Mr Ian Booker
54, Highview Road
Eastergate
PO20 3XB

Application for Planning Permission for Works or Extension to a Dwelling

Development: Garage conversion to habitable use and alterations to fenestration/openings
Location: 54 Highview Road Eastergate PO20 3XB

FOR MR & MRS BOOKER		
SITE 54 HIGHVIEW ROAD, EASTERGATE, WEST SUSSEX. P020 3XB		
TITLE EXISTING ELEVATIONS		
SCALE 1:100	DRAWN AH 06/21	DRAWING NO. 04 REV

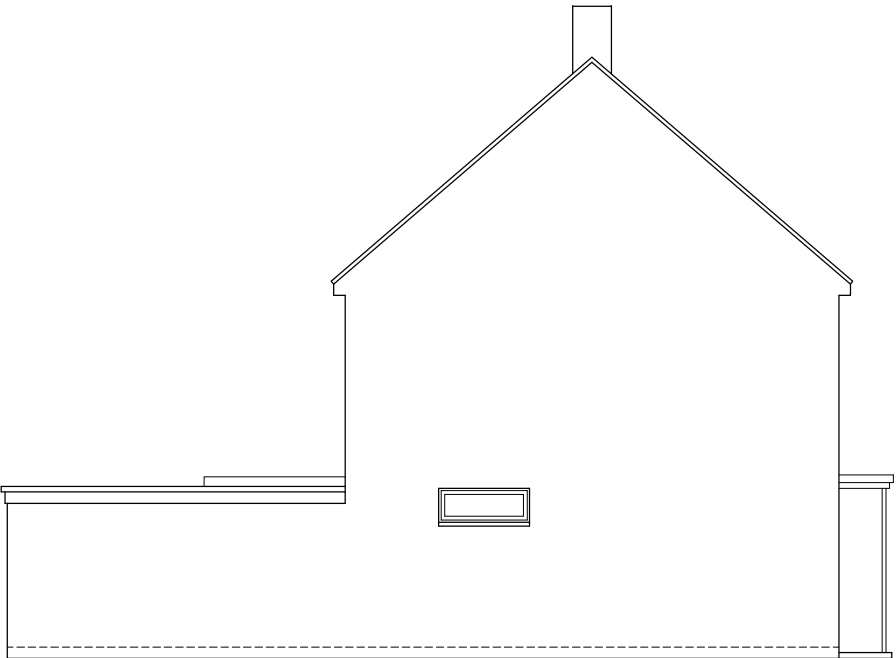
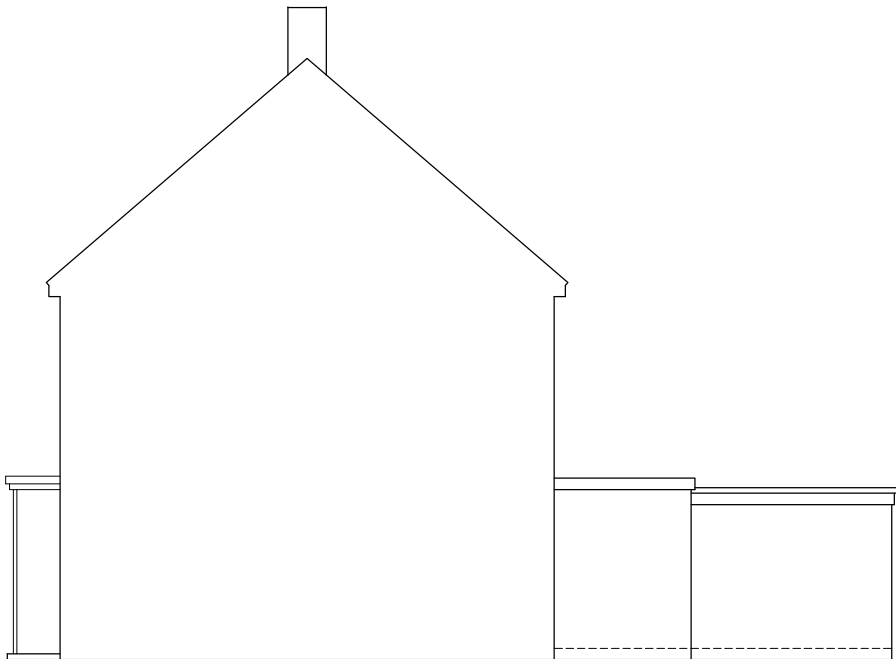
The window shown on the existing side elevation is missing from the existing ground floor plan. Please review and amend accordingly.
